Transport
State Transit

**Exhibition of Project Application for Broadway Building, University of
Technology Sydney (UTS) Broadway (MP 09_0212)**

I refer to your letter dated 23rd March 2011 seeking comment for a Project Application for the redevelopment of the Broadway Building, at University of Technology Sydney. State Transit appreciates the opportunity to provide input into this application.

Figure 16: Potential conflict points of the Construction Traffic Management Plan

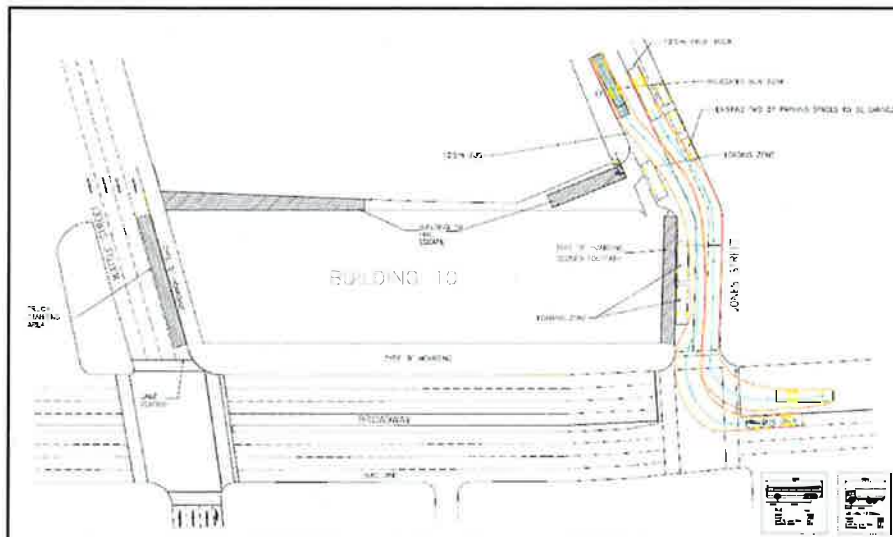
3. The turning paths as shown in figure 4 (Appendix M) can not be supported by State Transit. On review a number of conflict points have been identified which would create a dangerous situation for bus operators, customers, construction and general traffic.

The following have been identified as conflict points:

- The Bus passing the opposing vehicle on the right turn from Broadway into Jones Street.
- The bus passing the parked vehicles in the load zone near the intersection of Jones Street and Broadway.
- The bus passing a vehicle travelling in the opposing direction when the lane slightly diverges on Jones Street.
- The bus passing the parked vehicles in the load zone prior to the relocated bus zone.

Considerable improvements will need to be made before State Transit can accept this arrangement, alternatively Jones St could be made one way with trucks leaving the site via Jones Street, Thomas Street and Harris Street.
